OXFORDSHIRE COUNTY COUNCIL'S RESPONSE TO CONSULTATION ON THE FOLLOWING DEVELOPMENT PROPOSAL

Application No: 16/02482/REM

Proposal: Reserved matters to 13/00433/OUT - Siting, design, external appearance, landscaping, lap, infrastructure, points of access and associated works for 207 new dwellings

Location: Land South West Of Bicester Adjoining Oxford Road And Middleton Stoney Road Bicester

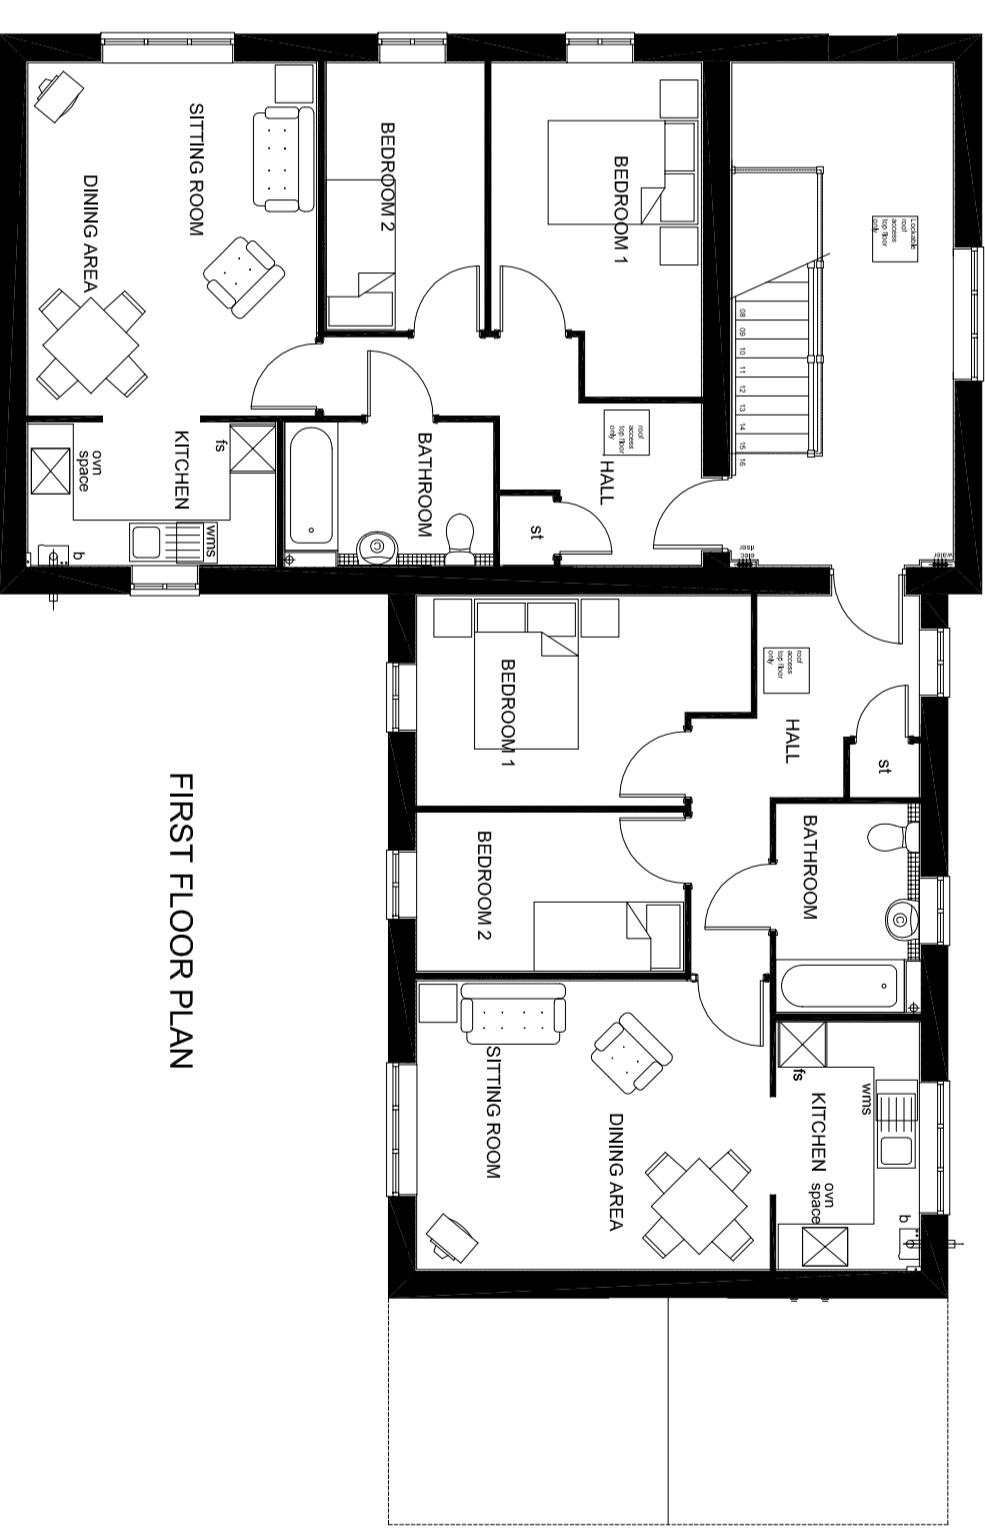
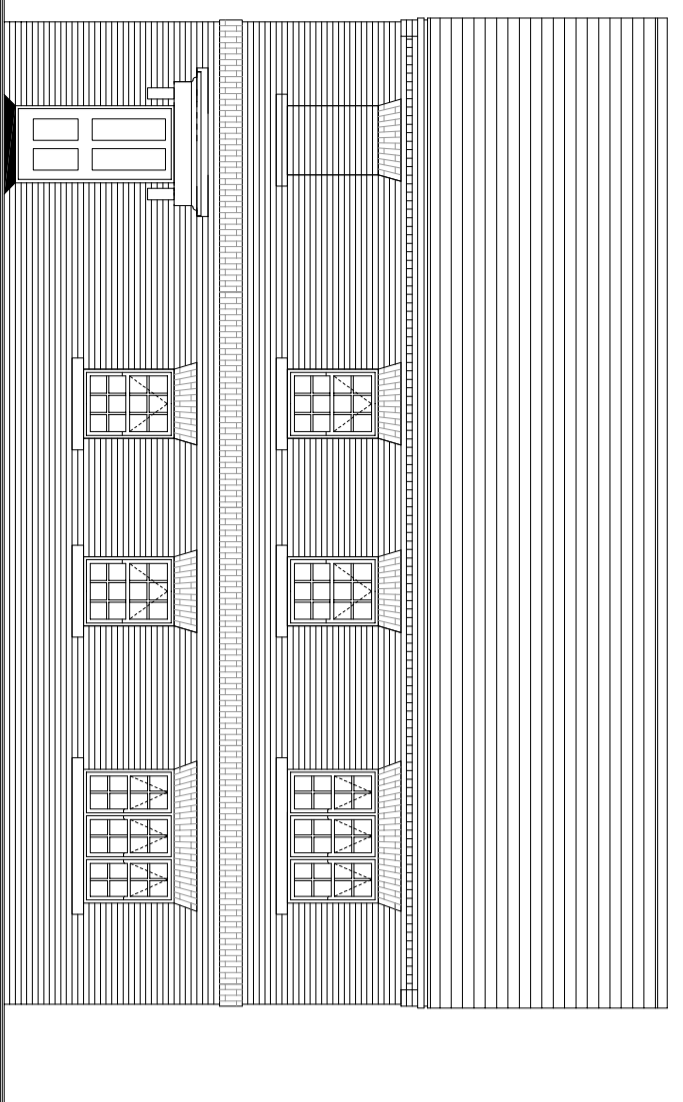
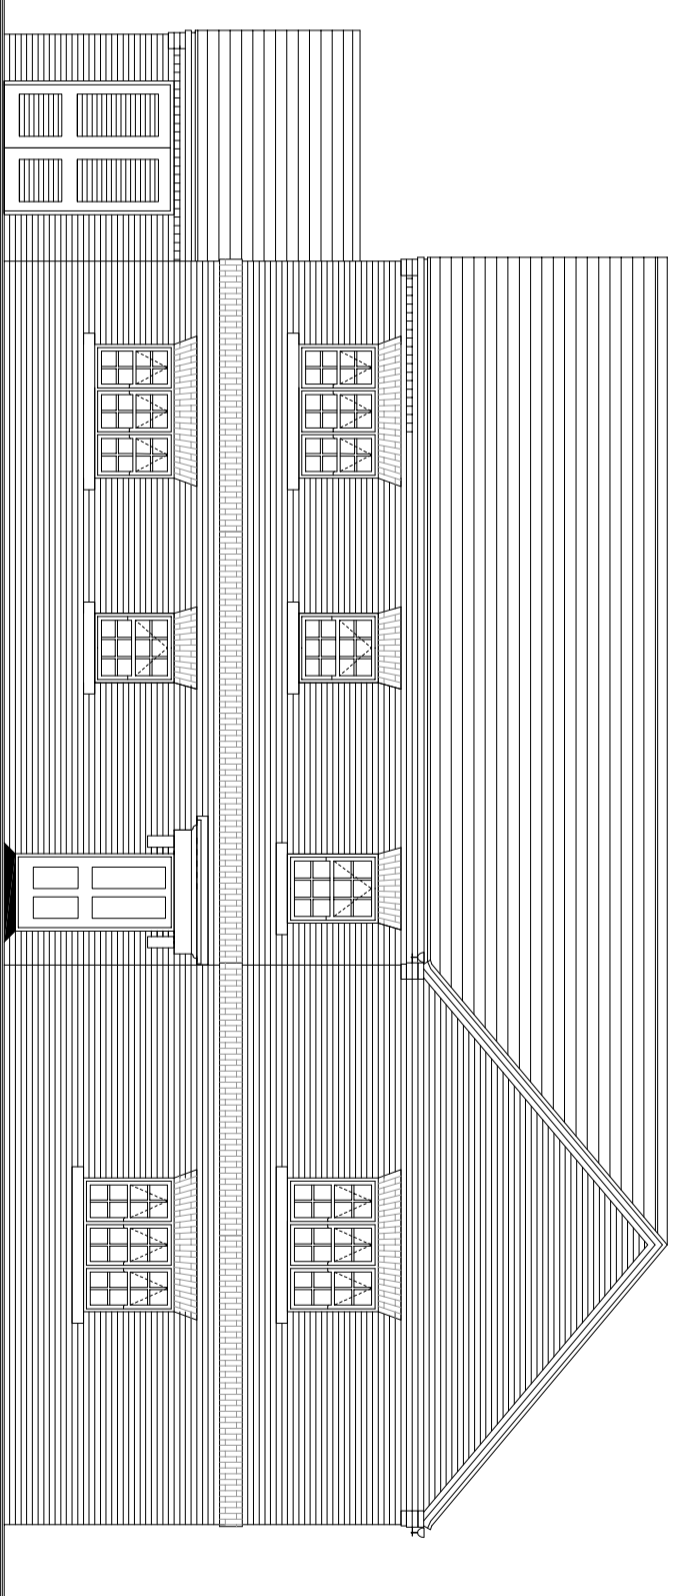
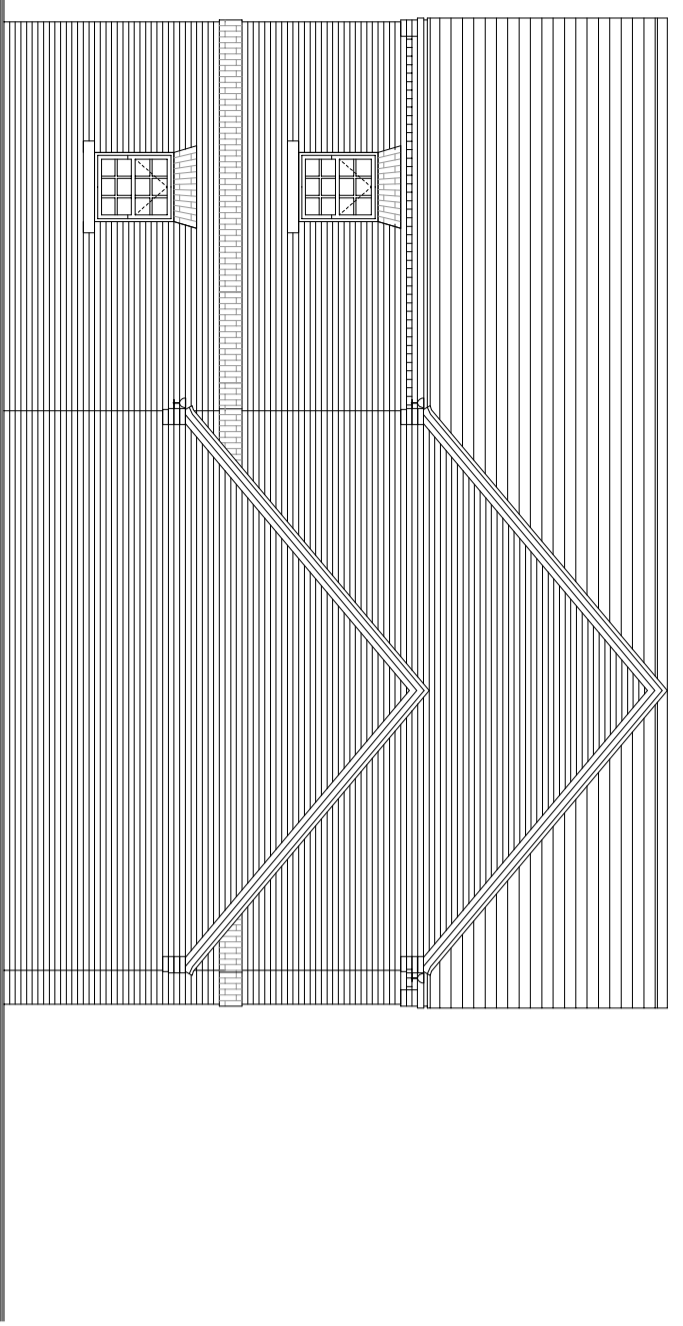
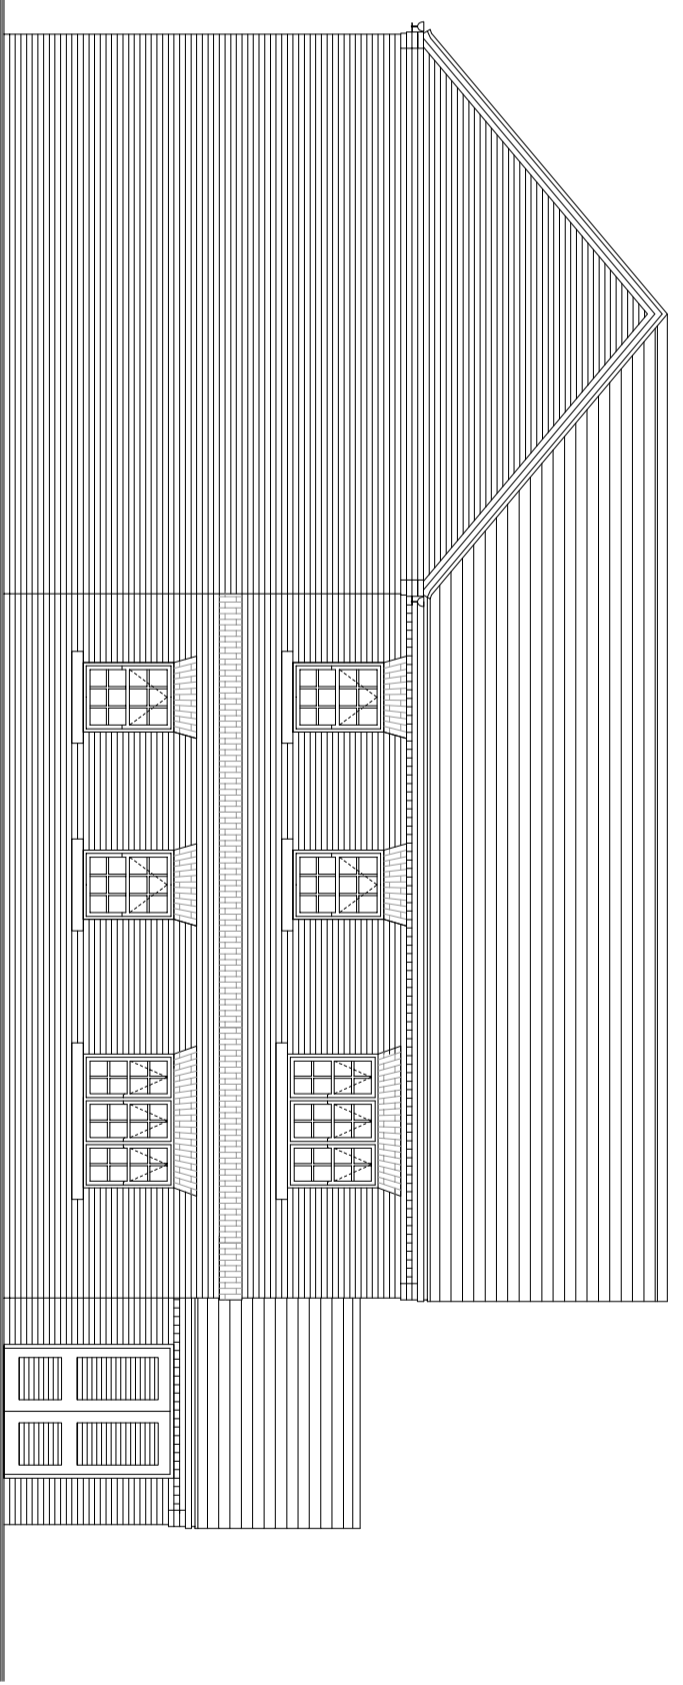
Also, much as the entrance to cycle storage serving apartments 182-187 is wide enough to provide a good access as shown by drawing number **HTPD_S7_01** entitled "*S8 Apartments – Plans and Elevations*", I am left concerned by the dimensions of the cycle store which measure about 2.7m x 3.2m. It looks like the proposed design is of the Sheffield type. The minimum spacing between Sheffield stands should be 1 metre and an adult size bicycle is about 2 metres long. Going back to the storage provided, only one row of 3 Sheffield stands can be accommodated within this space which is not sufficient for the residents and visitors. Further details of cycle storage must be provided to include the type of number of storage spaces. For more guidance to cycle storage standards, follow the link below;
https://www.cambridge.gov.uk/sites/default/files/docs/CycleParkingGuide_std.pdf
